Development Facilitation Team (DFT) – Review Comments

Project No: PR-2023-008993

Location: 8400 FLORENCE between BARSTOW and VENTURA

Application For: VA-2023-00307-SIDEWALK WAIVER (DHO)

COVER SHEET, SITE PLAN, & THERMAL BYPASS DETAILS
 PROJECT NAME: HOWARD RESIDENCE

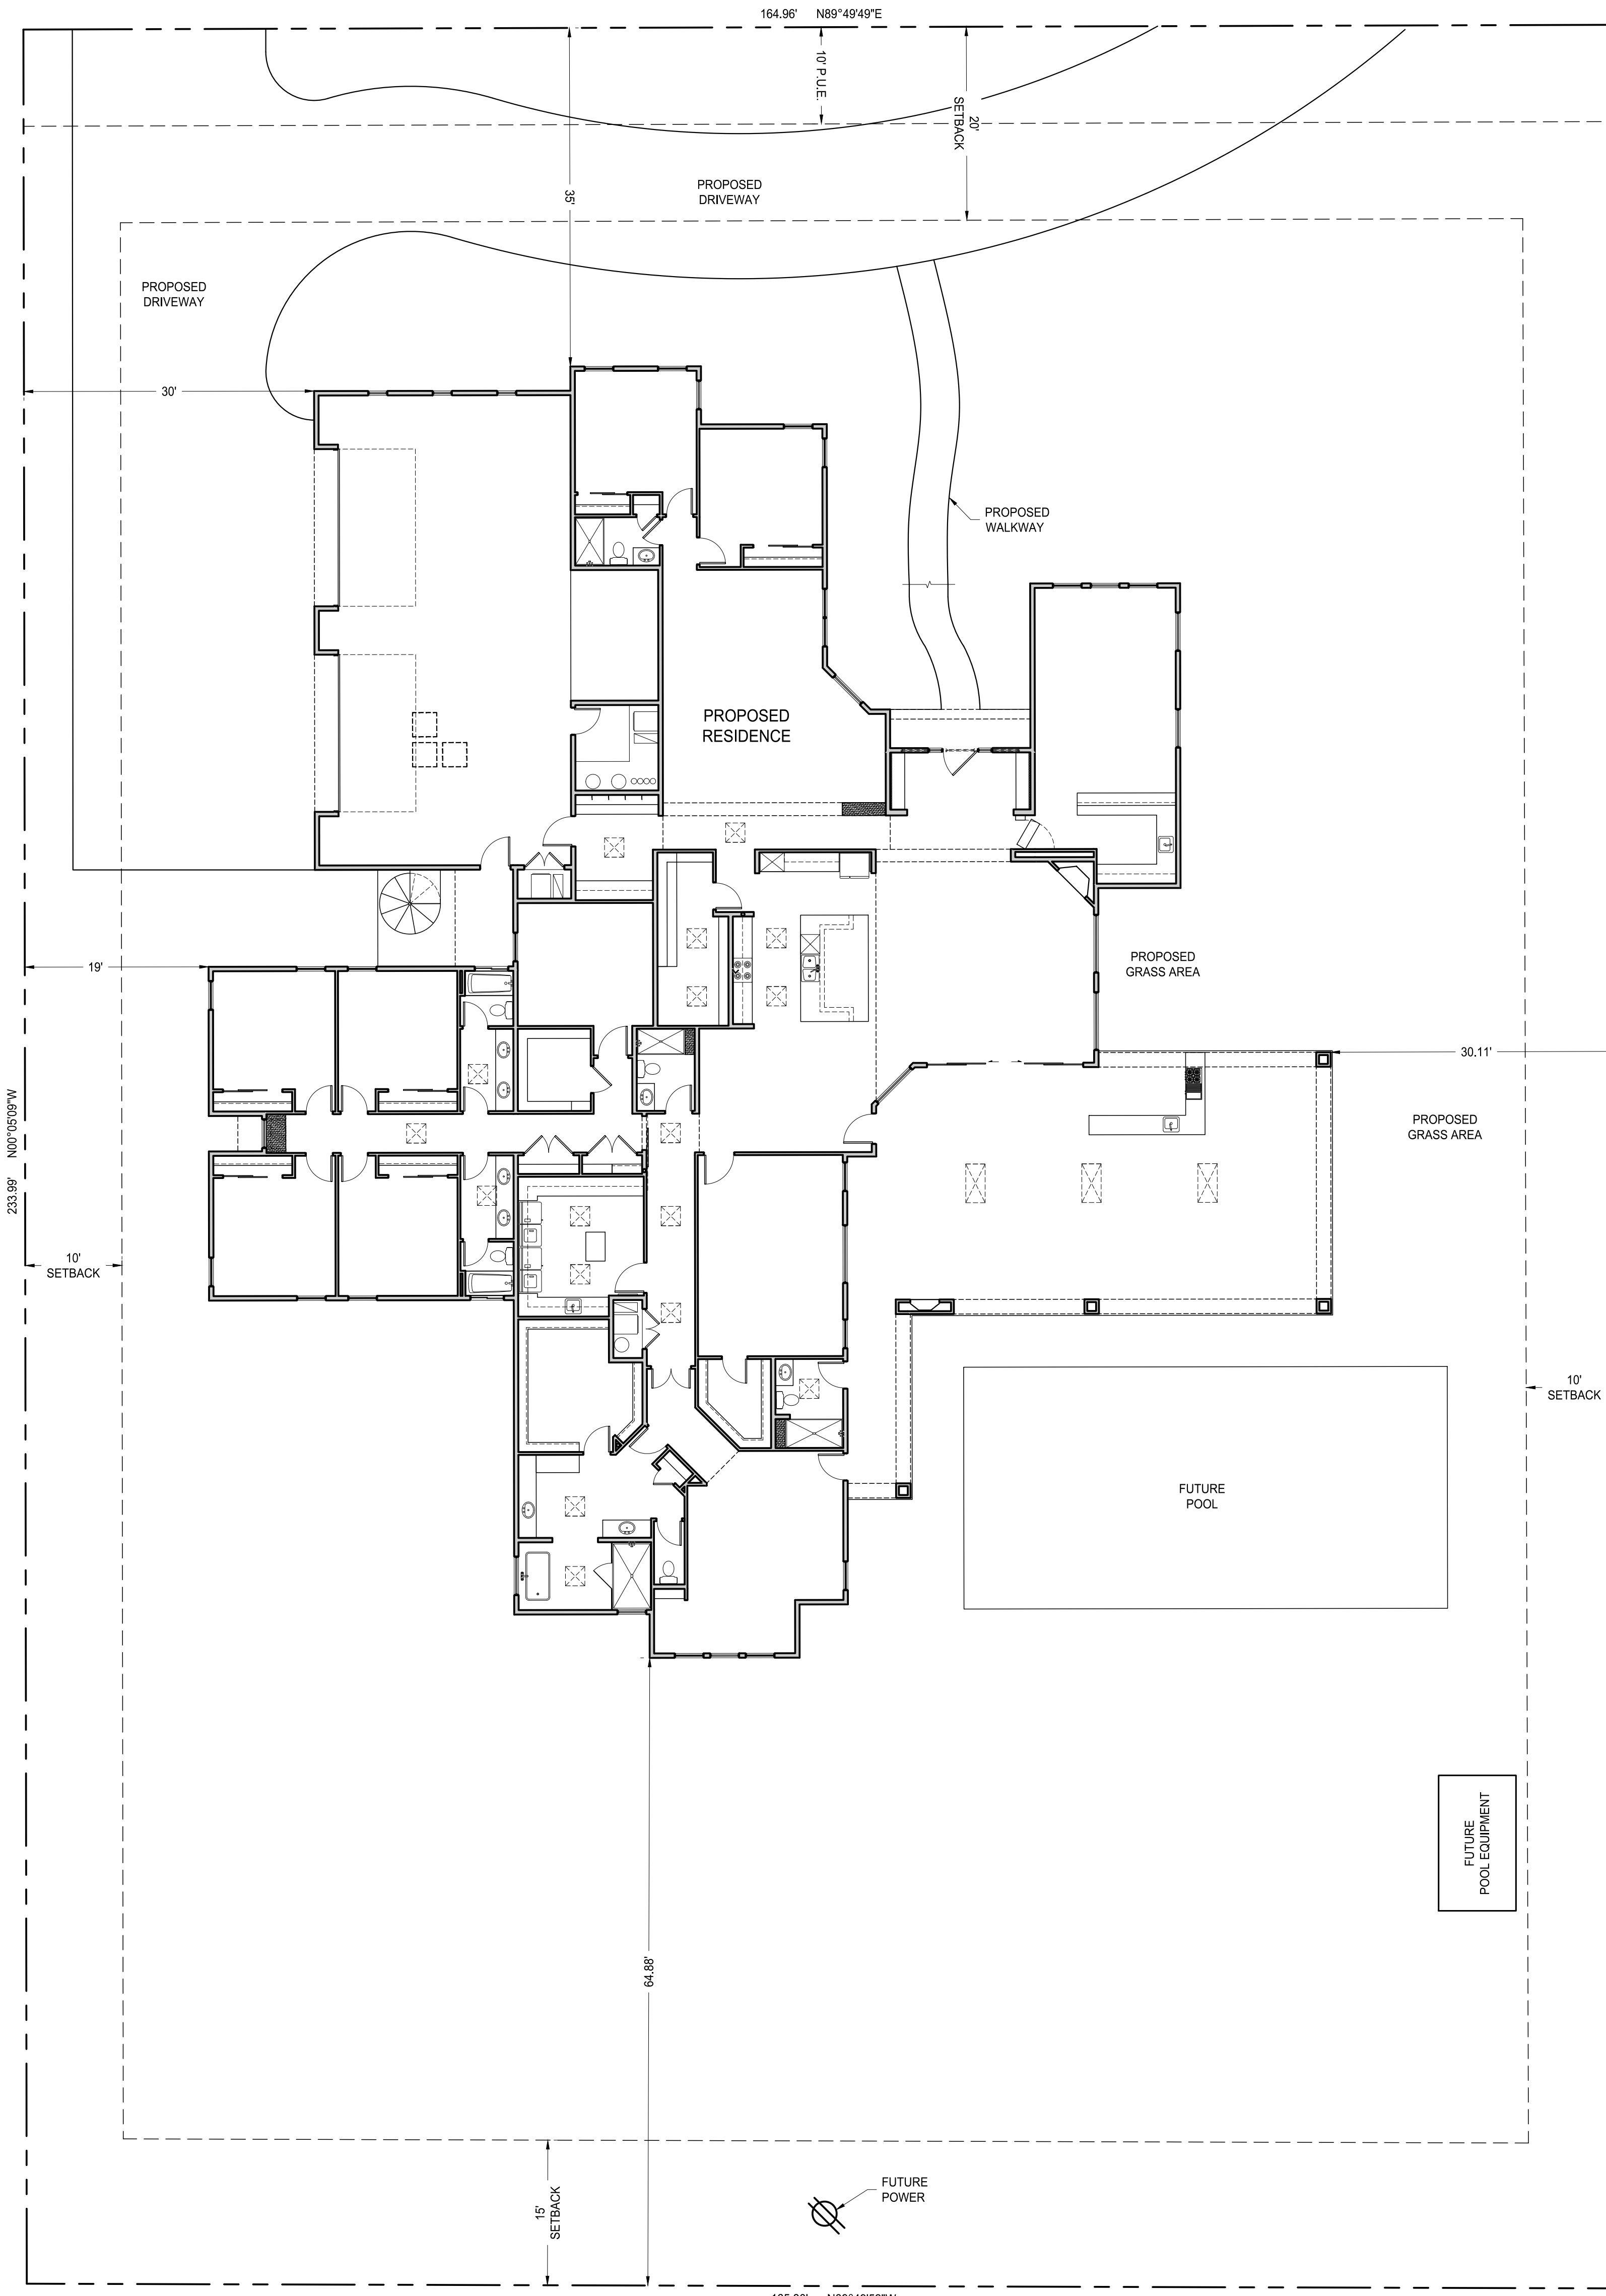
1. Florence is a Local street and requires curb and gutter and a 5' sidewalk with a 4-6' landscape buffer. Unfortunately, we are not able to waive the requirements of curb, gutter and sidewalk for this area. Transportation has been directed to enforce this requirement in this part of the City.

- This request features a proposed single family detached residence currently under Site Plan Administrative/Building Permit review. The Applicant is requesting that a sidewalk along Florence Avenue not be required as other residences along Florence in the vicinity of the subject property don't have sidewalks; Florence Avenue NE is a local street, and DPM requirements note that a 5-foot wide sidewalk and a 4-6-foot landscape buffer zone are required along the portion of Florence Avenue fronting the subject property. Additionally, the Applicant is requesting that curb and gutter along Florence Avenue not be required.
